Accessibility Design Review Report

Proposed Data Centre Development
1 Sirius Lane Cove West NSW 2066

Prepared for: Greenbox Architecture
Job No: 77710
Date: 17th December 2018
Revision: -
Phase: DA Submission

AWE Doc No Added 110319
ATSYD2-SSD-REP-ACC-001

Project Status SSD		
Drawing Title GROUND FLOOR PLAN _ RL11.0		
Drawing Number	Issue	
ATSYD2_SSD_DRG_ARC_0101

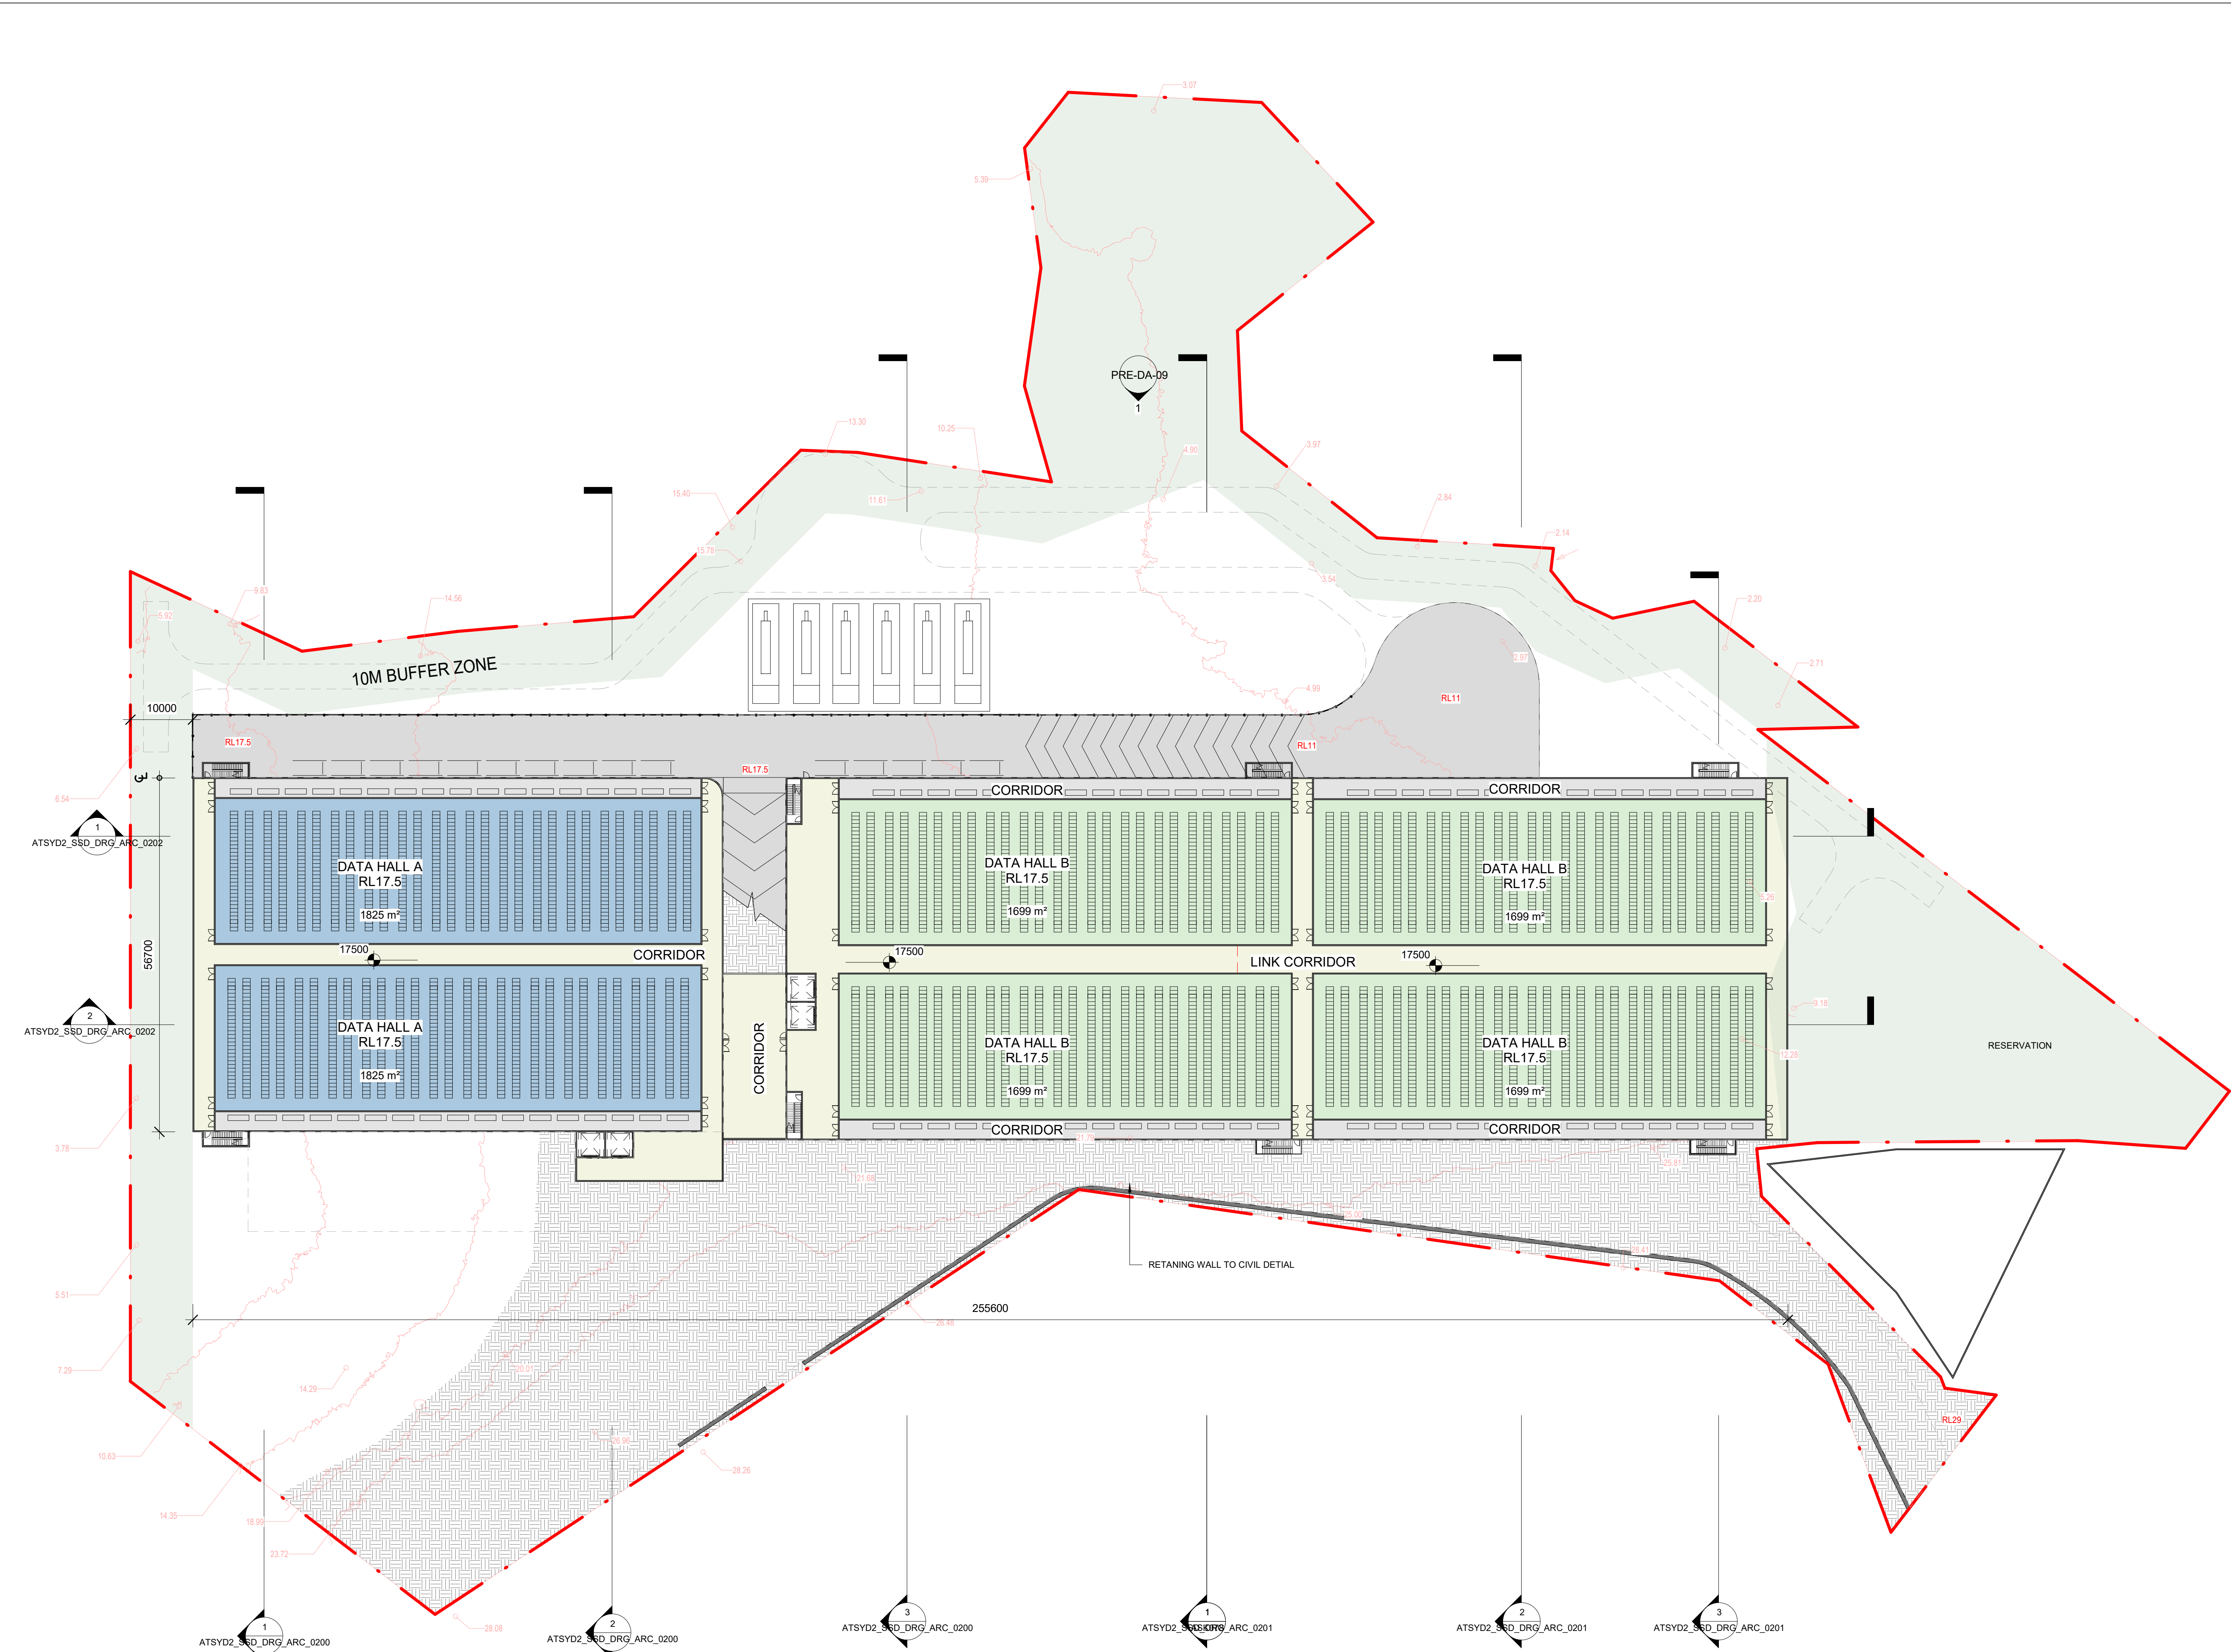
3.	<u>Carparking</u>	<p>Provide accessible carparking spaces in accordance with D3.5 of the BCA. Number of accessible spaces to conform to Table D3.5. Design of space to AS/NZS 2890.6 2009.</p> <p>Annotate bollard in shared zone</p>	<p>Annotate proposed locations of accessible carparking along with consideration as to proximity of / path of travel to the Administration building.</p>

11.	<u>Ambulant Cubicles</u>	<p>Male and Female Ambulant Cubicles are required on each level where gender facilities are provided in addition to UASF.</p> <p>Design to comply with Clause 16 of AS1428.1-2009</p>	<p>Annotate male and female ambulant cubicles as required</p>
